# **Green Hill Solar Farm**

## **EN010170**

### **Statement of Common Ground: Milton Keynes City Council Revision B**

Document Reference: EX5/GH8.3.3\_B  
Infrastructure Planning (Examination Procedure) Rules 2010

Figure 4.20
Green Hill Site G
Landscape and Ecology Mitigation Plan
[EN010170/APPGH6.4.4.20]
5/2(a)

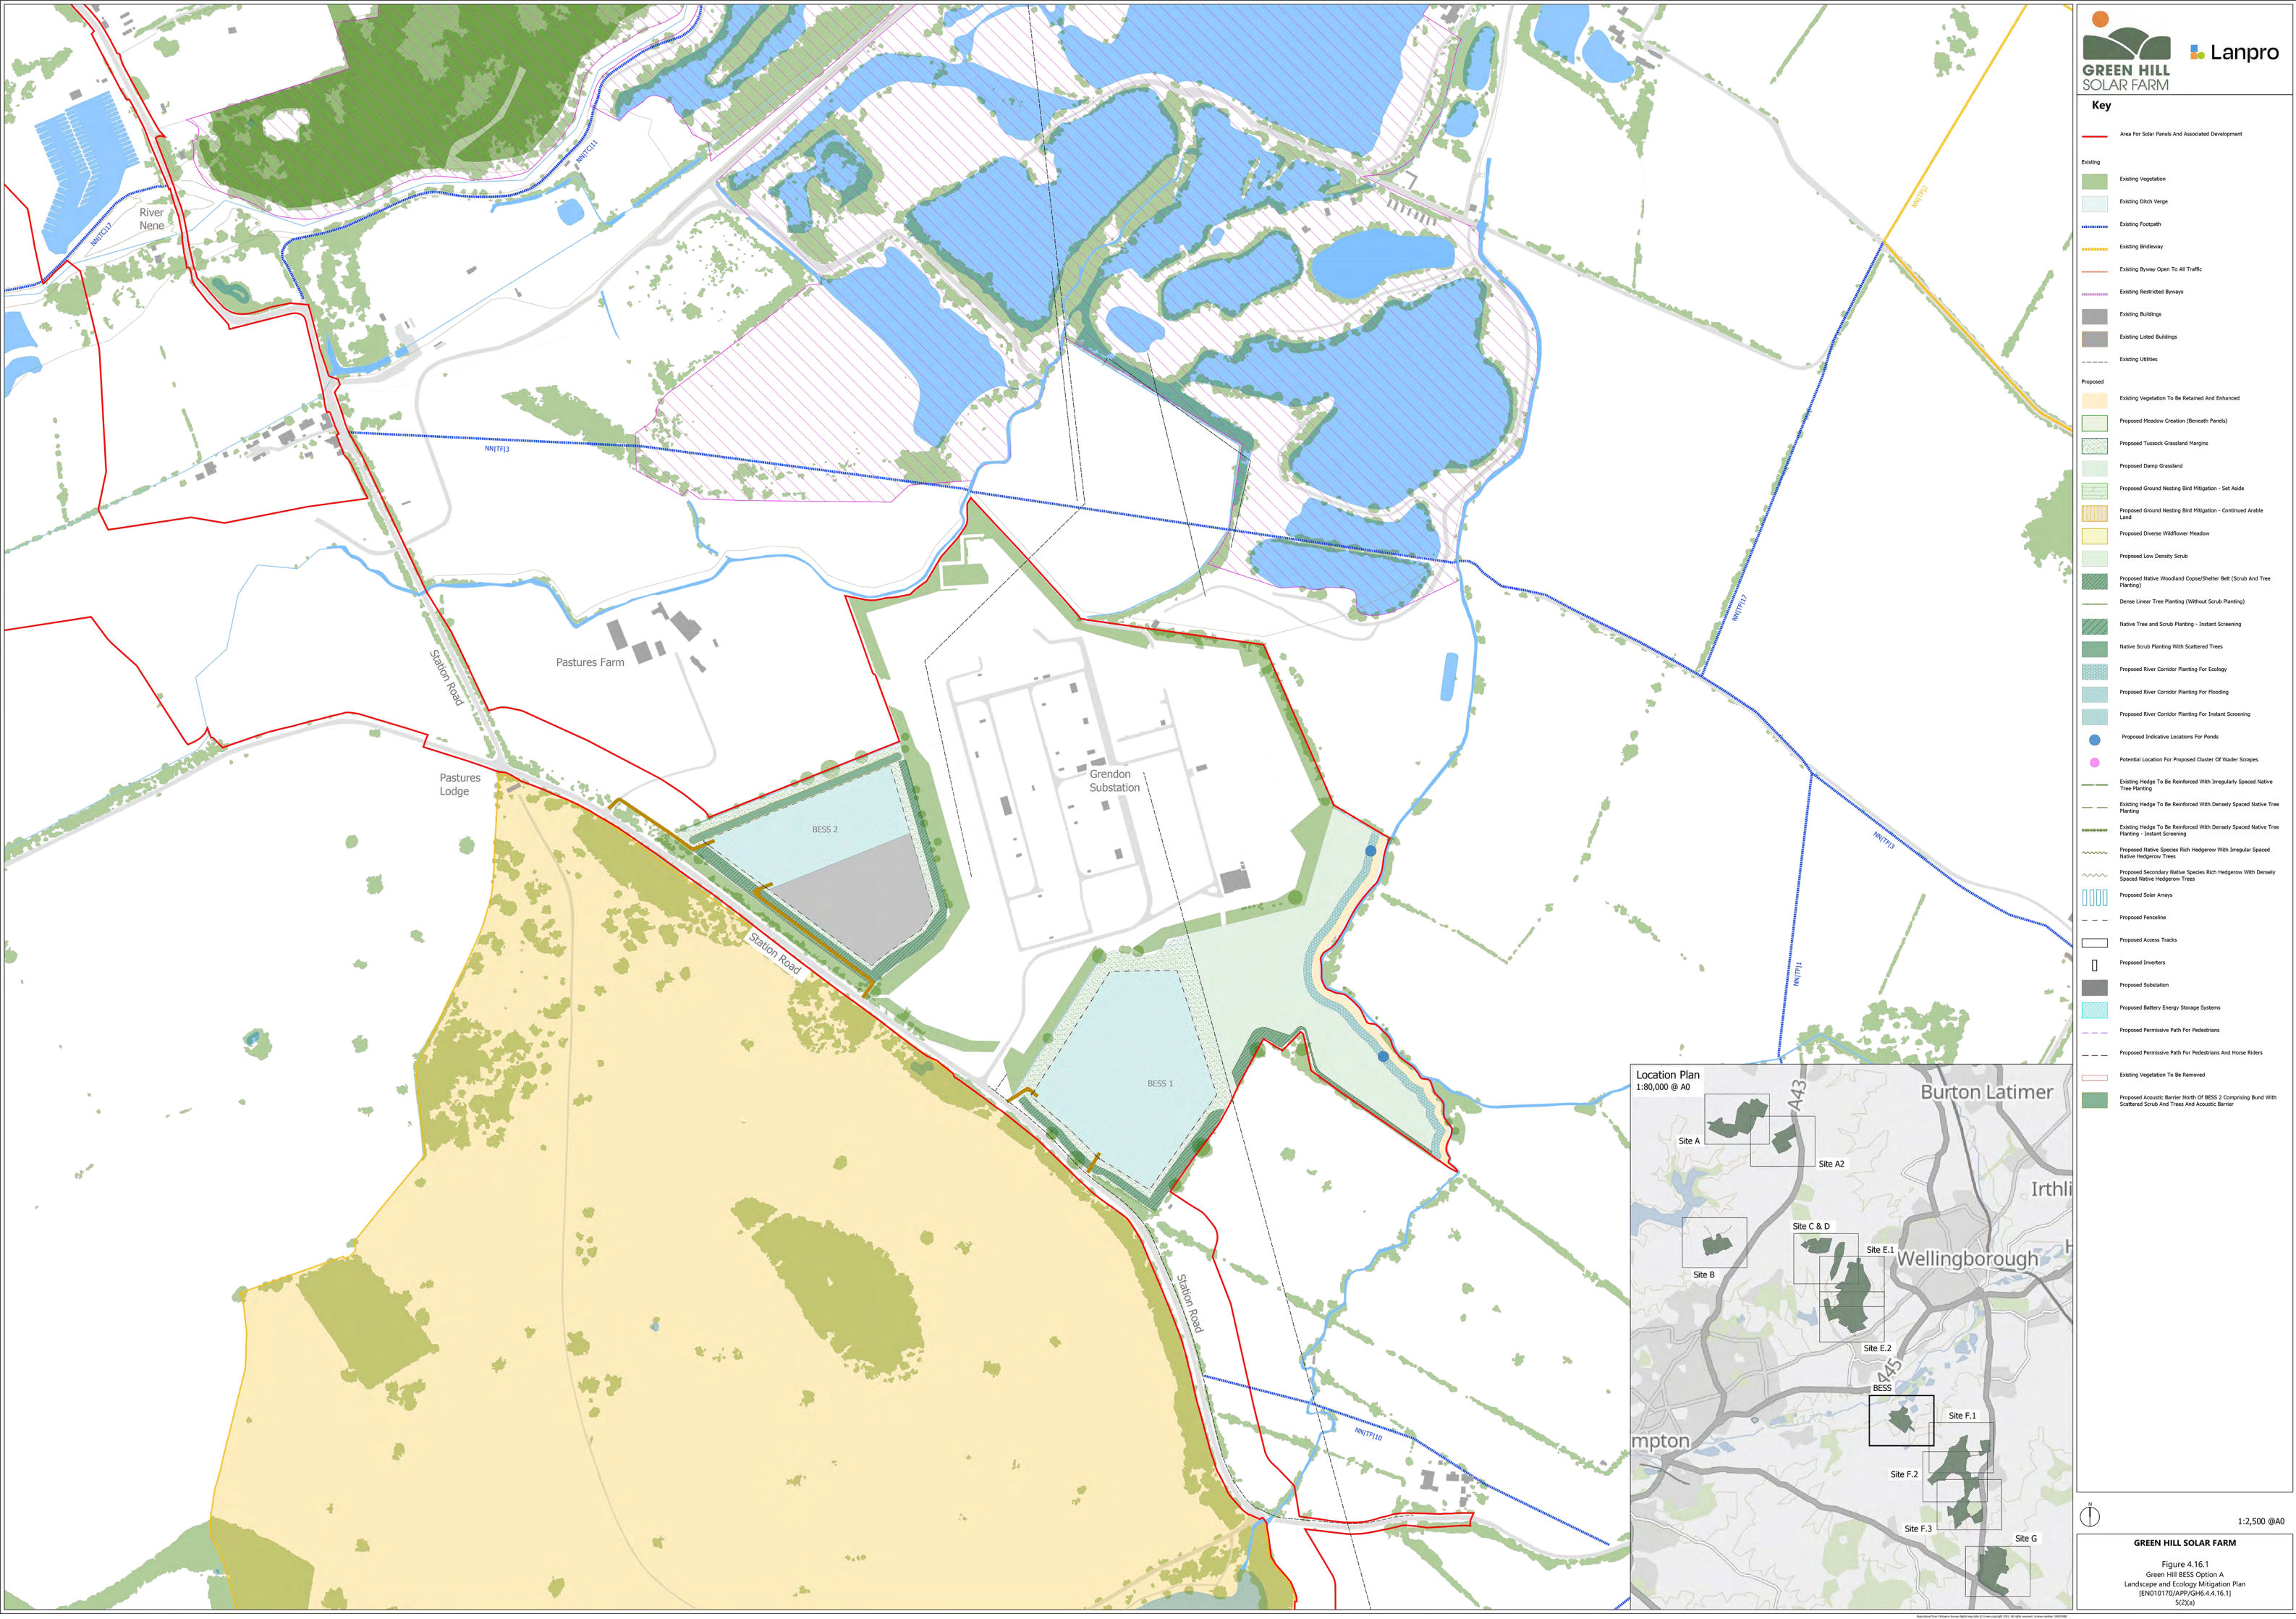
Matter	Details of Matters for Discussion	Applicant Position	Consultee Position	Status
			<p>mitigation would result in a positive effect to landscape character during the lifetime of the development, only that the planting would go so far as to mitigate the significant adverse effects associated with the proposals within the Local Study Area – it is important to note that mitigation does not remove adverse effects to landscape character, with Moderate / Minor Adverse effects to landscape character anticipated beyond Year 15 for the remainder of the lifetime of the scheme.</p>		
LVIA-11	Presentation of Assessment Findings	<b>ES Chapter 8: Landscape and Visual [APP-045]</b>	<p>The approach to the assessment is considered acceptable as set out in Section 8.6 of <b>ES Chapter 8: Landscape and Visual [APP-045]</b>. This non-technical summary is to assist readers understand the conclusions of the LVIA and contains a list of potentially affected receptors with summarising narrative to provide context and identify what the key issues are.</p>	<p>Beneficial effects on landscape character are overstated, the landscape character changes will not be reversed and there will forever be the imprint of the solar farm development on the local landscape character and existing views currently enjoyed over open countryside from public rights of way will be lost to screening buffers.</p>	Matter Under Discussion

Matter	Details of Matters for Discussion	Applicant Position	Consultee Position	Status
			<p>Scheme shown on <b>Landscape and Ecology Mitigation and Enhancement Plans (Figures 4.10-4.20)</b>. The <b>Outline Landscape and Ecological Management Plan [EX5/GH7.4_D]</b> (the 'OLEMP') is secured by Requirement 7 of Schedule 2 of <b>Draft Development Consent Order Revision [EX5/GH3.1_D]</b></p> <p><b>Applicant's Response to the Consultee</b></p> <p>Woodland planting has been implemented to enhance screening between GF12 and GF13 where Three Shires Way intersects Green Hill G off the A428. The additional woodland planting in this area will be implemented under both design options (A and B) for Green Hill G. ES Figure 4.20: Landscape and Ecology Mitigation Plan G (Revision A) <b>[CR2/GH6.4.4.20_A]</b> and Figure 8.2.14 Landscape and Ecology Mitigation Plan G (Option B)</p>

Matter	Details of Matters for Discussion	Applicant Position	Consultee Position	Status
			[CR2/GH8.2.14] have been updated to reflect this change.		
LVIA-13	Landscape Assessment	<b>ES Chapter 8: Landscape and Visual [APP-045]</b>	<p>The Landscape Assessment set out in <b>ES Chapter 8: Landscape and Visual [APP-045]</b> are considered acceptable</p> <p><b>Applicant’s Response to the Consultee</b></p> <p>The LVIA does not conclude that the proposed landscape mitigation would result in a positive effect to landscape character during the lifetime of the development, only that the planting would go so far as to mitigate the significant adverse effects associated with the proposals within the Local Study Area – it is important to note that mitigation does not remove adverse effects to landscape character, with Moderate / Minor Adverse effects to landscape character anticipated beyond Year 15 for the remainder of the lifetime of the scheme.</p>	<p>The proposed Landscape and Ecology Mitigation and Enhancement Plans primarily function as mitigation rather than landscape character enhancement and would not fully outweigh the landscape fabric change arising from the introduction of introduced buffer planting, solar infrastructure, fencing, access tracks, substations and other associated paraphernalia. As such, it is the Council’s judgement that there will still be an adverse effect to Landscape Fabric at Year 15 and for the duration of the scheme. The landscape design treatment to address the issue of screening a solar farm will impose a particular local landscape character that will not be in keeping with areas assessed as special landscape. We disagree that the solar farm development</p>	Matter Under Discussion
